WELWYN HATFIELD COUNCIL – DEVELOPMENT CONTROL
DELEGATED REPORT

APPLICATION No:	S6/2007/1545/FP
------------------------	------------------------

The application seeks full planning permission to convert the existing loft space to habitable accommodation including the insertion of one hipped roof dormer window within the front roofslope to provide for two additional bedrooms within the roofspace

REVISIONS.			CONTRACT.	DETAIL.
NO.	DETAILS.	DATE		
			Extension at 45 Northaw Road East, Cuffley, Herts	Elevations as Proposed
			CLIENT.	
			DRAWN. rgl	DRAWING NO.
			REVISION.	SCALE. 1:100
			STATUS.	mp.26325

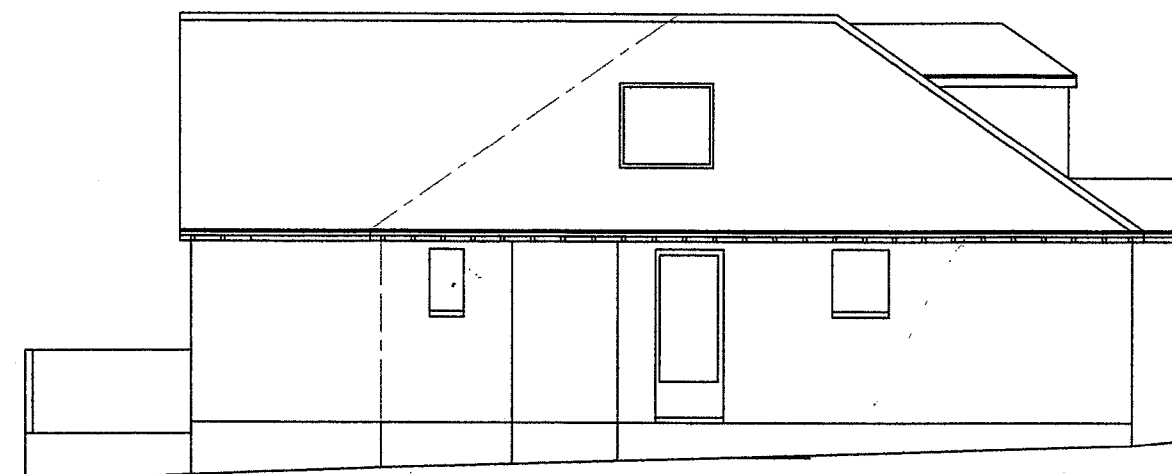
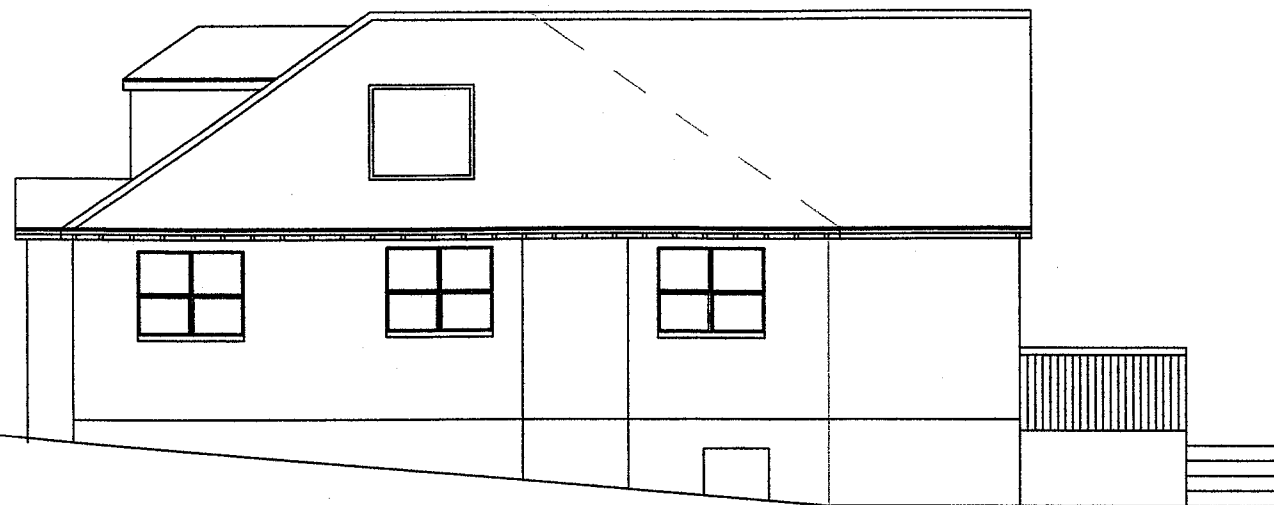
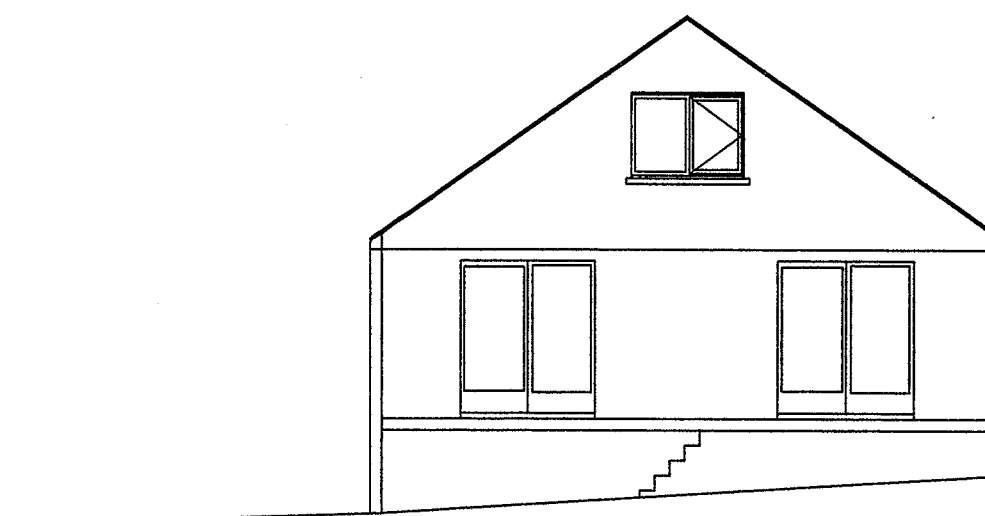
It is acknowledged that the proposal would alter the existing character of the bungalow by extending the existing roofline to the rear and creating a gabled end. However, the proposed extensions are not considered to be as substantial and bulky as those within the immediate vicinity. The properties directly opposite the site in particular have various dormer windows within each elevation.

The proposed dormer window maintains a hipped roof design and has been set below the existing ridgeline, is subservient to the existing roof and has been set in by at least 1 metre (2 metres from the bottom of the dormer) from both flank walls. This complies with Section 5.2 of the Supplementary Design Guidance 2005.

The extension has been set in by the minimum requirement of 1 metre from the common boundary, however due to the spacing of buildings within the locality of the site; it is considered that a greater separation distance should be maintained to reflect the existing spacing within the street scene. Consequently, this does not comply with Section 5.2v of the Supplementary Design Guidance 2005 and Policy D2 of the Welwyn Hatfield District Plan 2005.

REVISIONS.			CONTRACT.	DETAIL.
NO.	DETAILS.	DATE		
			Extension at 45 Northaw Road East, Cuffley, Herts	Plans as Proposed
			CLIENT.	
			DRAWN. rgl	DRAWING NO.
			REVISION.	SCALE. 1:100
			STATUS.	mp.245

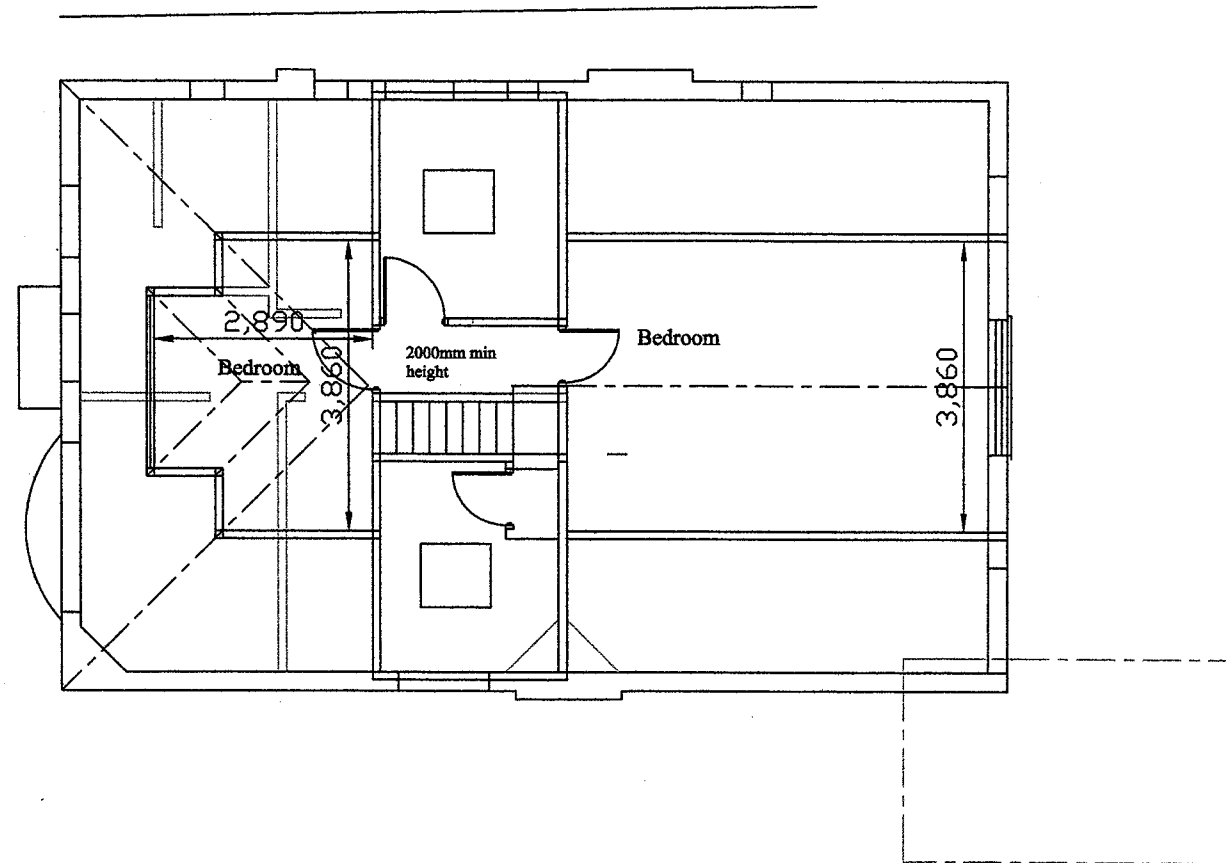
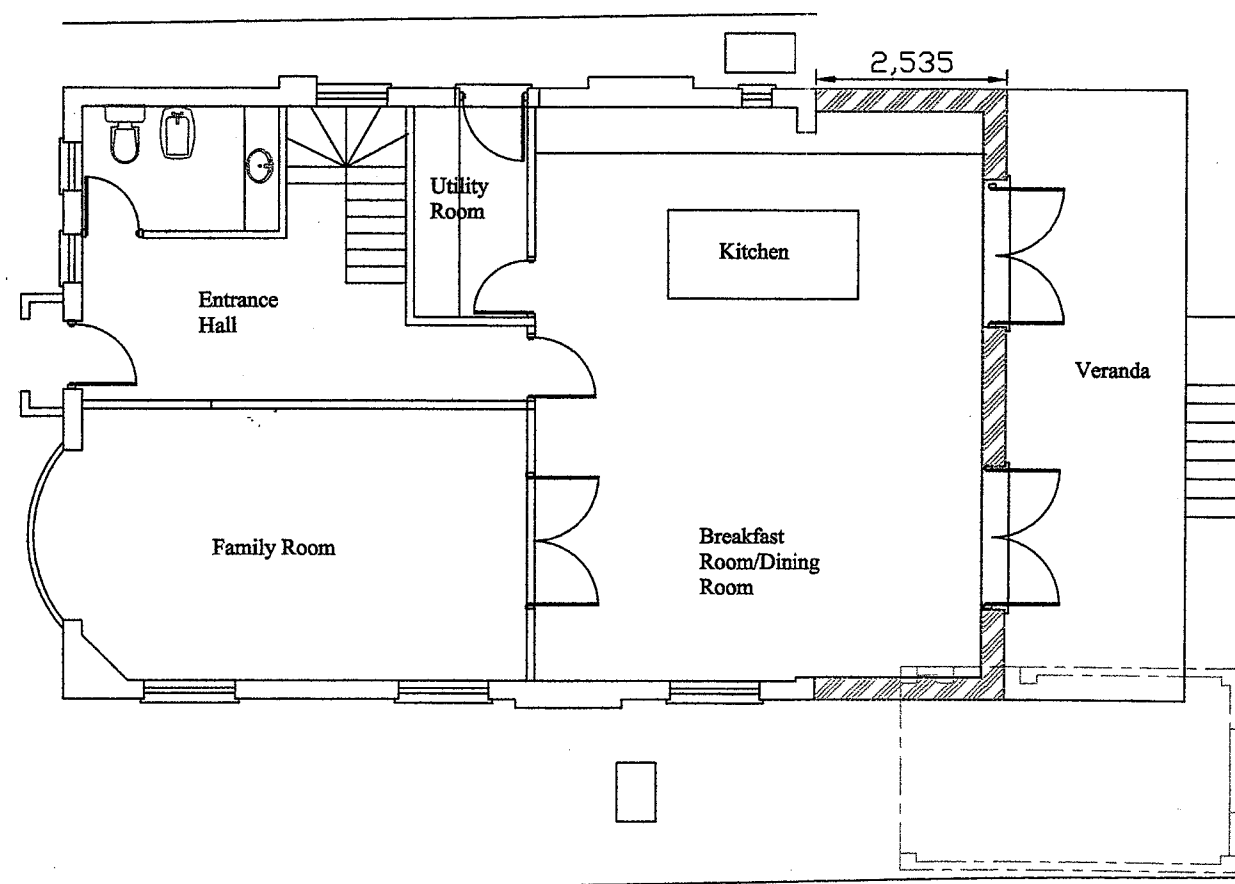
The adjacent property at 43 Northaw Road East has an existing single storey side and rear extension on the boundary, which has a depth of approximately 4 metres from the original building line. It is therefore considered that the proposals at 45 Northaw Road East would not have a detrimental impact on residential amenity as although the extension is two storeys, it would only protrude an additional 2.5 metres to the rear, which is short of the existing extension at 43 Northaw Road East.

The property at 47 Northaw Road East is separated by an existing driveway (a distance of approximately 5 metres) and consequently the proposed extensions, taking into account the demolition of the existing detached garage on this elevation and the separation distance, are considered to be acceptable. The rear projection of 2.5 metres is not considered to be dominant, overbearing or cause substantial loss of sunlight/daylight to the occupiers of 47 Northaw Road East.

Cuffley is located within Zone 4 as designated within the Supplementary Planning Guidance-Parking Standards. It is specified that a dwelling containing 4+ bedrooms within this location should provide for a maximum of 3 car parking spaces. The application form states that one car parking space within the garage would be lost as part of the development. However, three spaces are available on site, which is considered adequate and in compliance with the revised parking spaces and complies with Policy M14 of the Welwyn Hatfield District Plan 2005.
